Our Ref: 20048269
PINS Ref: EN010119
Date: 21 January 2026
Telephone: [REDACTED]

Application by North Falls Offshore Wind Farm Limited (“the Applicant”) for an Order granting Development Consent for the proposed North Falls Offshore Wind Farm (“the Proposed Development”)

I refer to your letter dated 18 December 2025 (the letter) in which the Secretary of State (SoS) invites all Interested Parties to comment on responses received to the previously issued request for further information (dated 26 November 2025) regarding the above Development Consent Order (DCO) application. In response, Essex County Council (ECC) in conjunction with Tendring District Council (TDC) [jointly referred as “the Councils”] would like to provide the following comments.

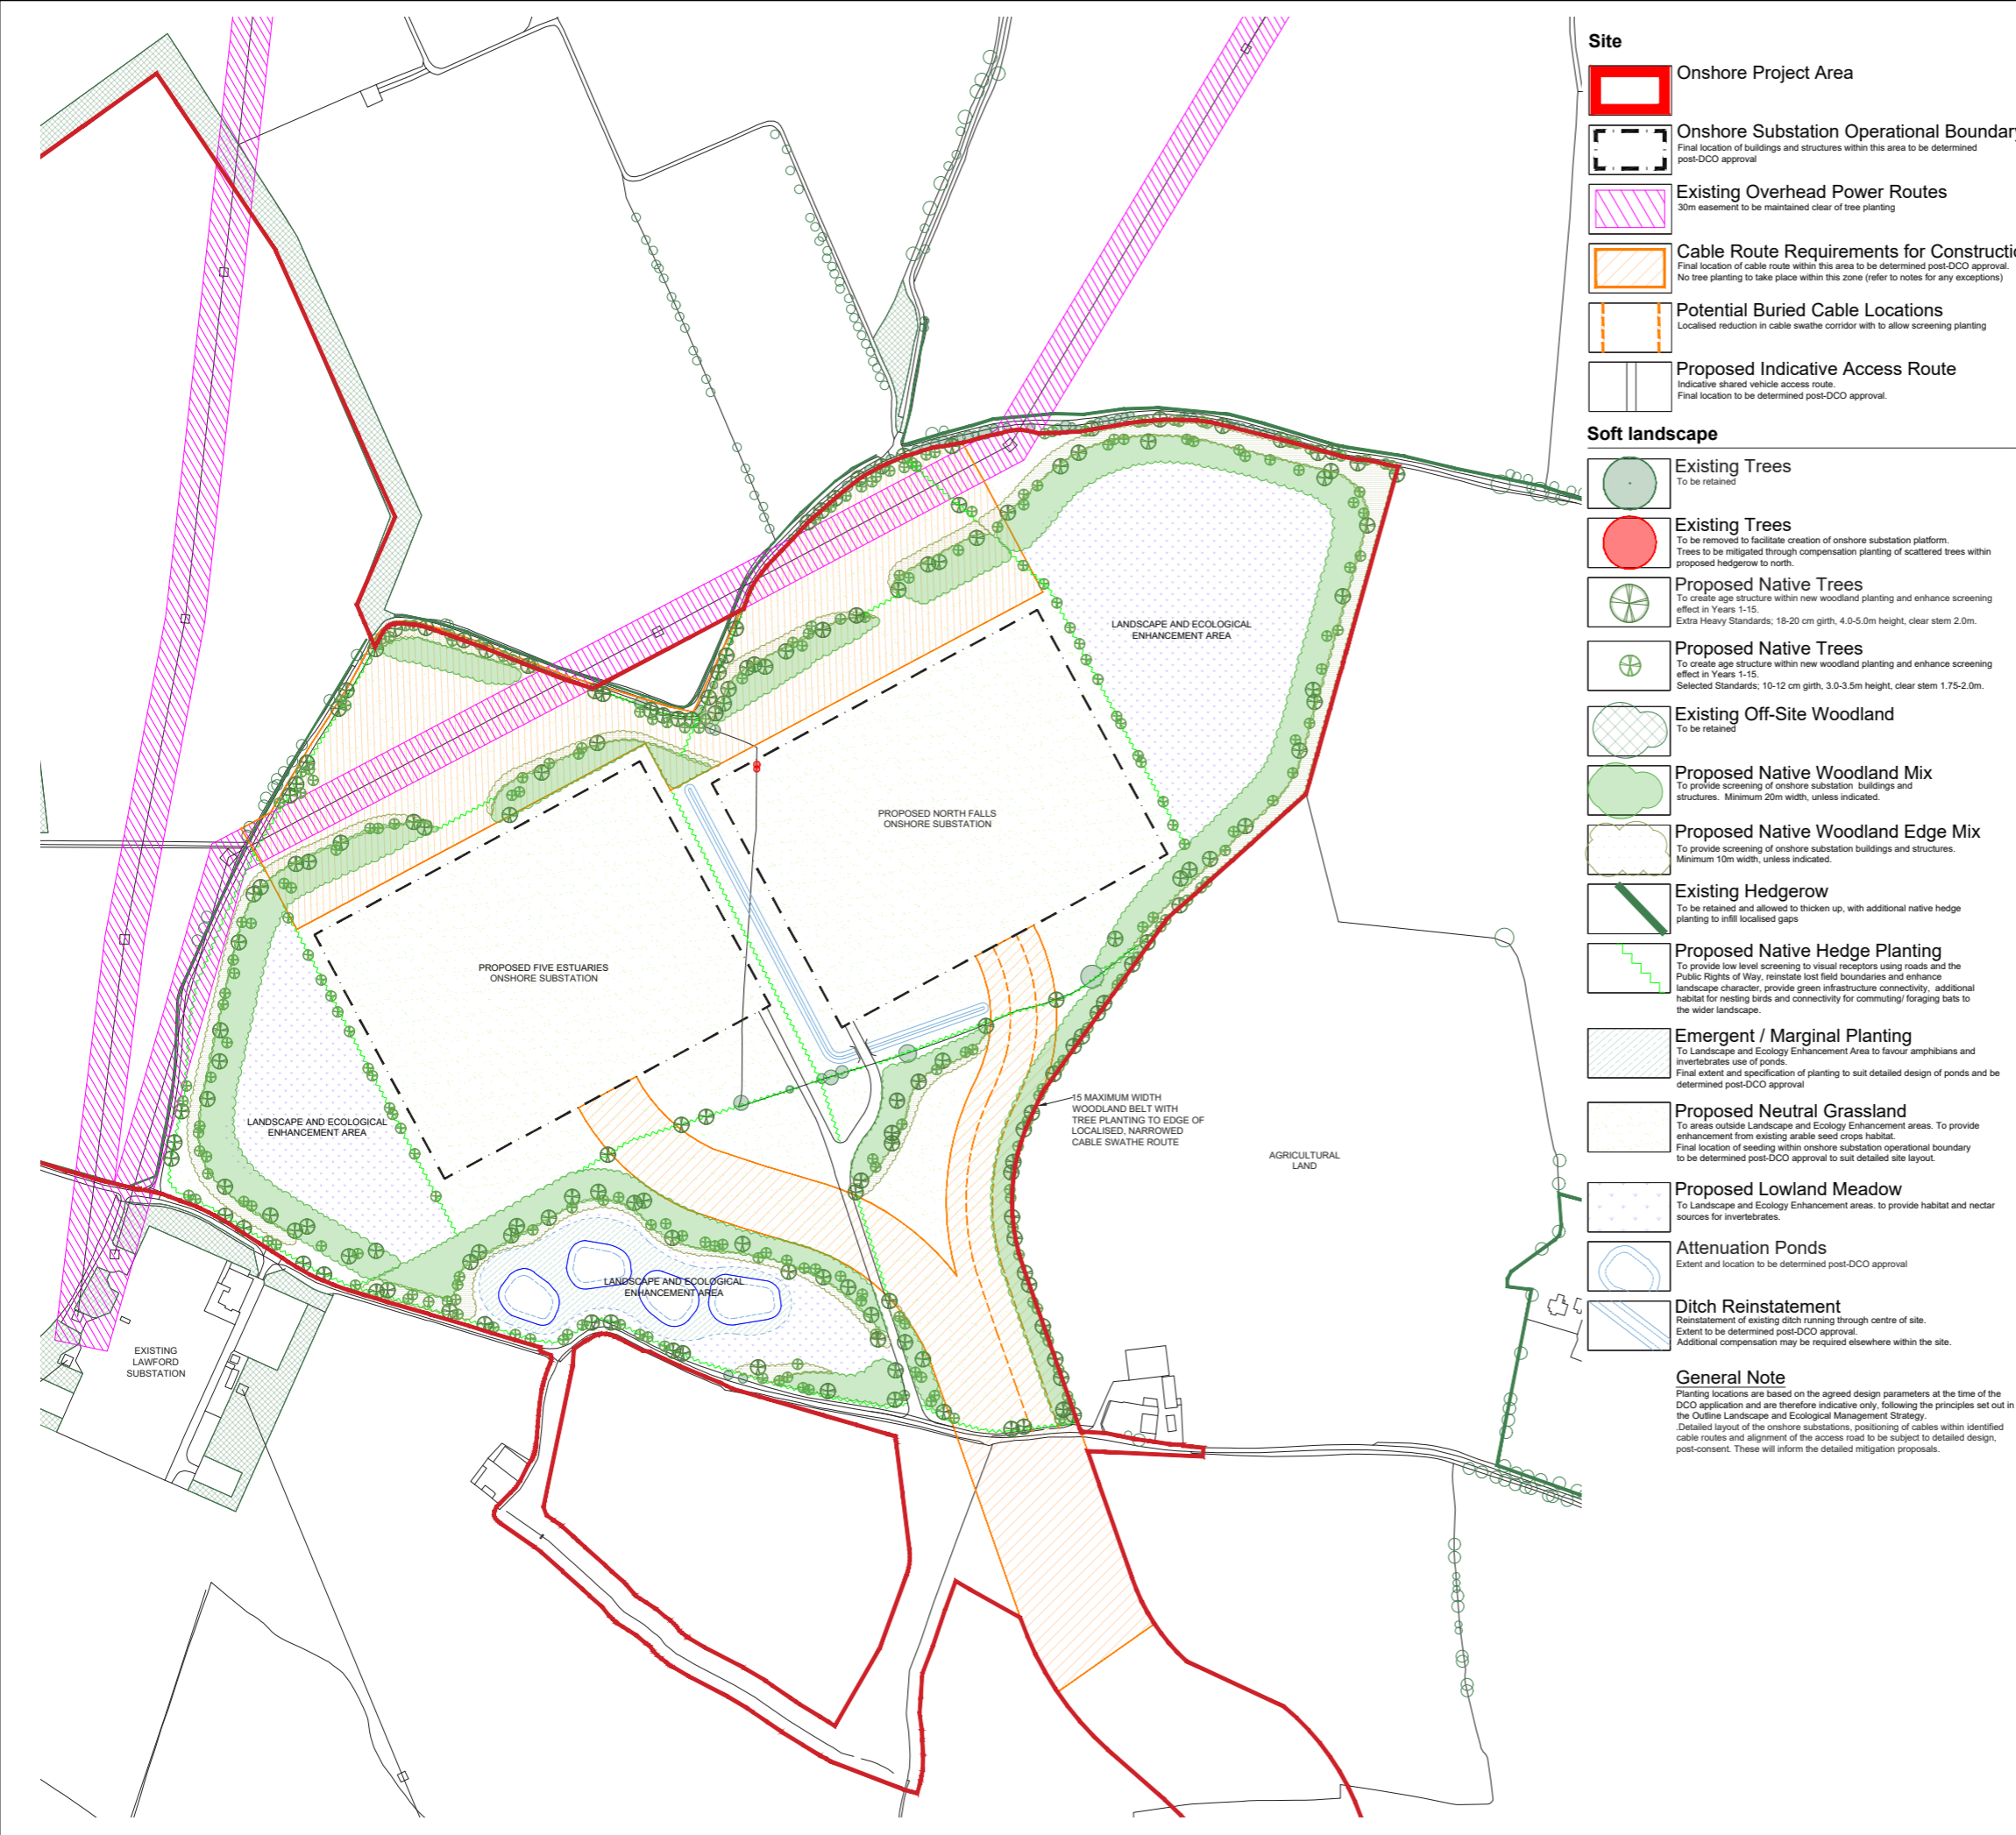
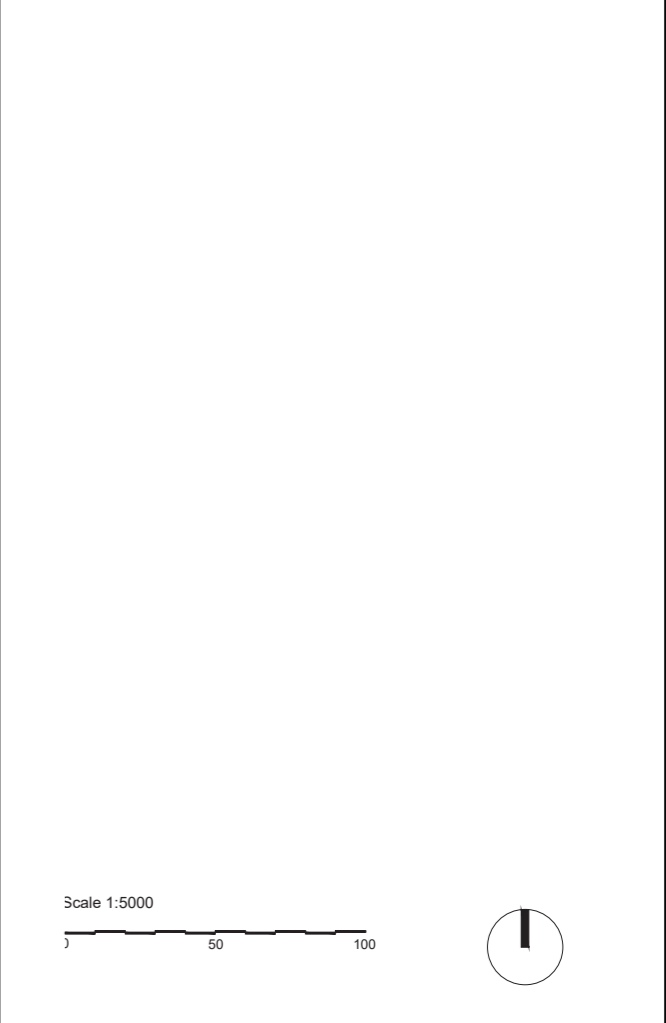
According to the submitted 2.3 Works Plans – Section C (Final Issue A) of the N2T DCO application (extracts below as **Figure 1**), the Councils note that the proposed Ardleigh Road widening works of the N2T project would require a strip of land with a depth of roughly 15m to 25m on the northern side of Ardleigh Road within the North Falls proposed order limits (highlighted yellow in **Figure 1** below). Such road widening works would directly interfere with the proposed joint structural visual and landscaping planting along the northern side of the road as well as the proposed landscape and ecological enhancement area of the North Falls and Five Estuaries projects.

The Councils therefore continue to raise serious concerns on the integration between these 3 projects and the achievability of the claimed mitigation and/or enhancement as stated in the Environmental Statement. It is unclear how the proposed works of the 3 projects would align to each other and the potential implications on the layout of the onshore substations, Biodiversity Net Gain calculations as well as their respective landscape mitigation.
